**From:** Rebecca Edgson  
**Sent:** 08 February 2022 11:39  
**To:** Richard Horton  
**Subject:** From planning 22/0031/INVAL Christchurch Farm Sixteen Foot Bank

Drawing Title:	Site Plan
----------------	-----------

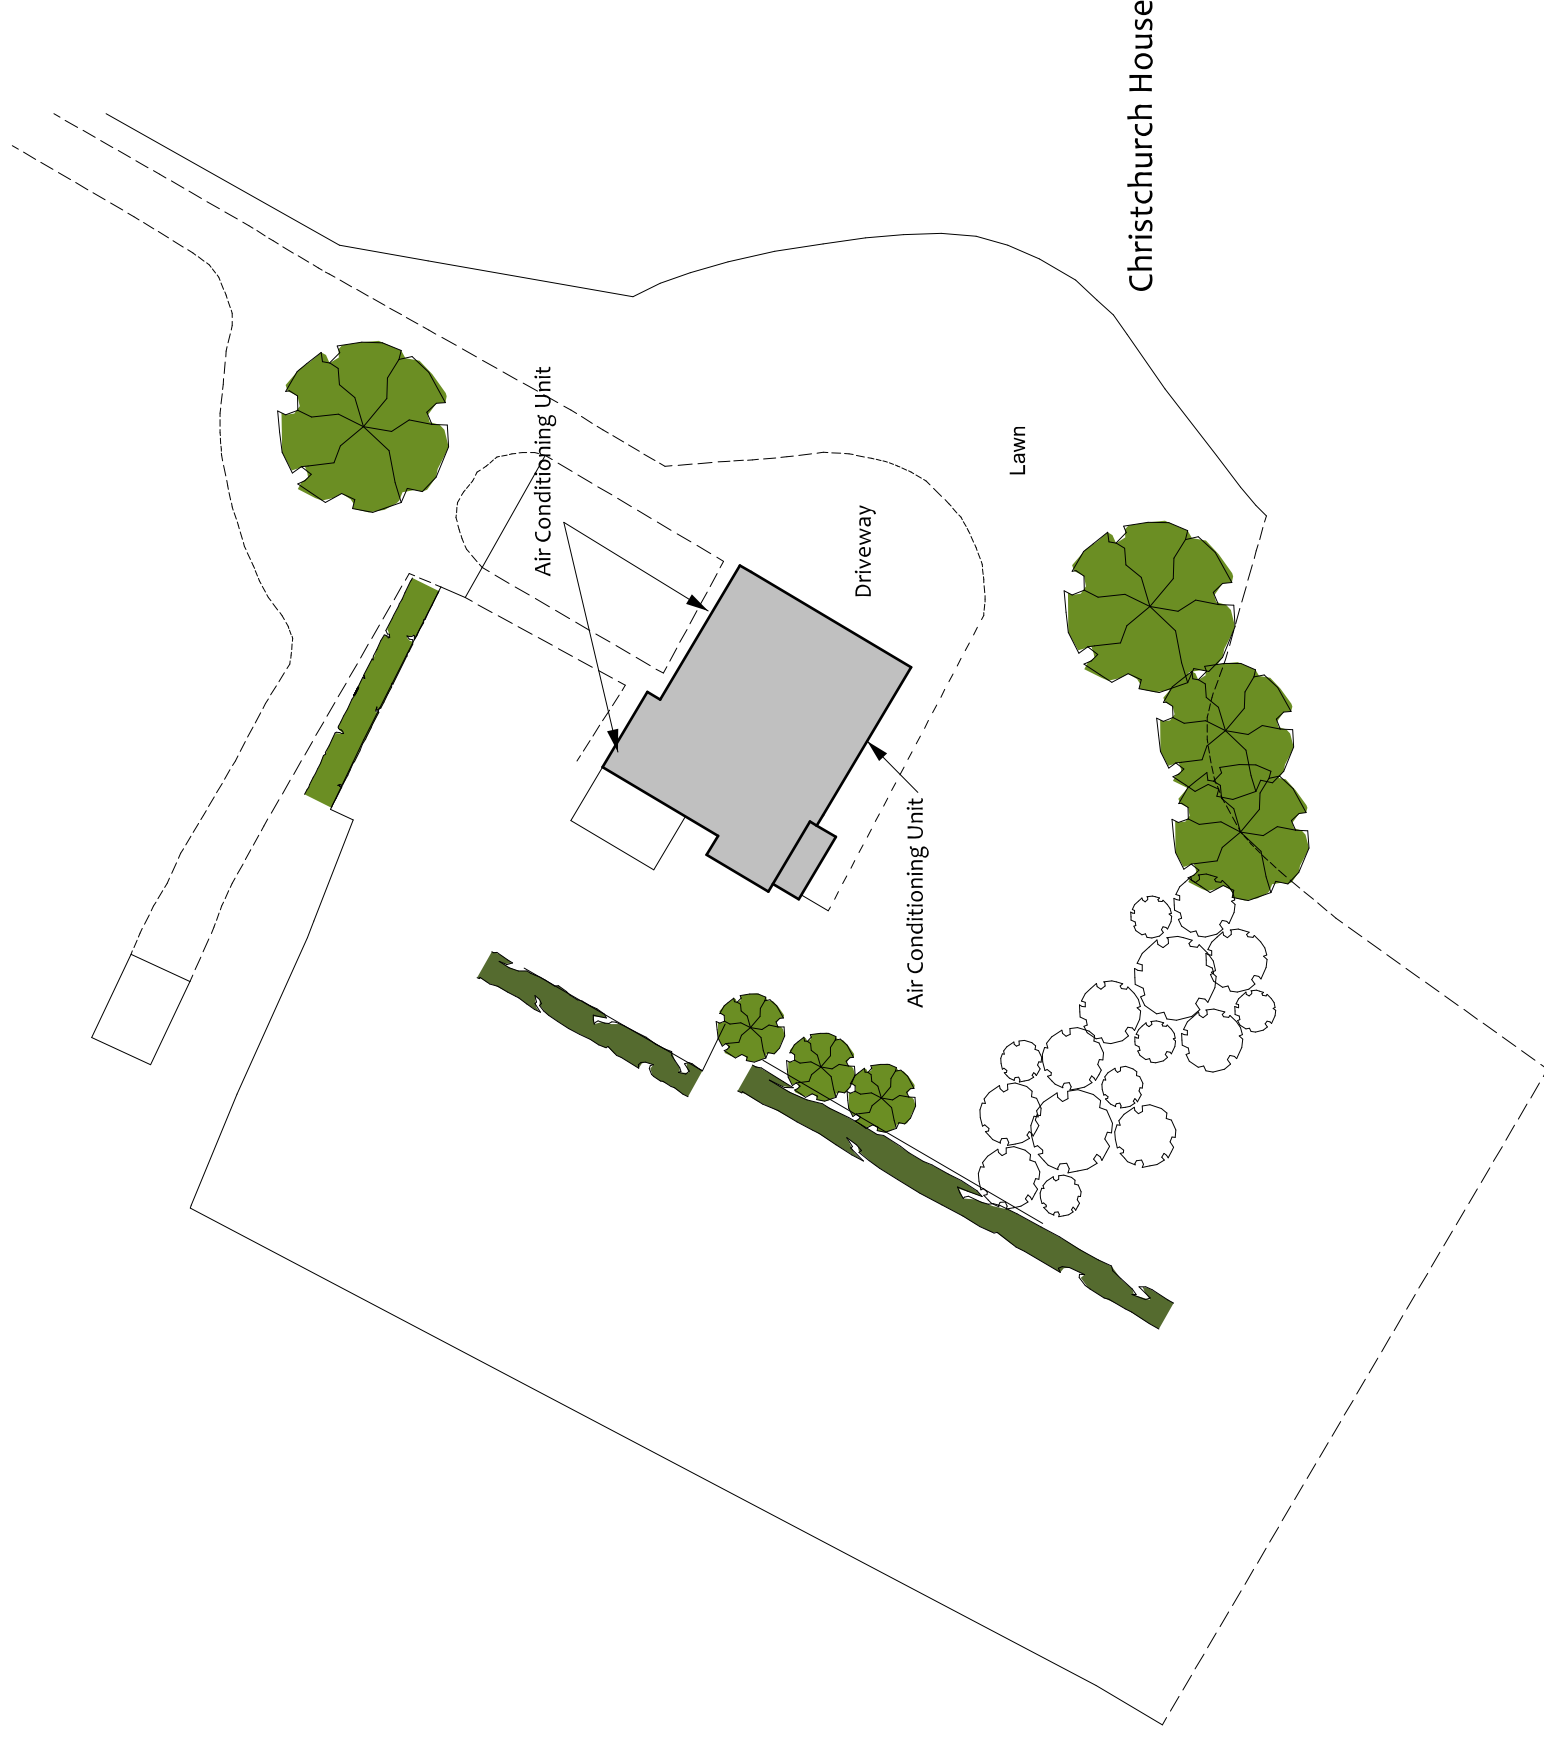
Thank you for the amended information received. I have printed out the plans and the scale bar does not correspond with the scale that is written on the plans. Perhaps you can send in a different format to see if this works. The plans I printed fit on A4 paper and I printed to actual size.

Please can you add to the drawings what scale the drawings are and before re-sending check that the scale corresponds with the scale bar. The scale should be to a recognised scale which can be found on a scale rule.
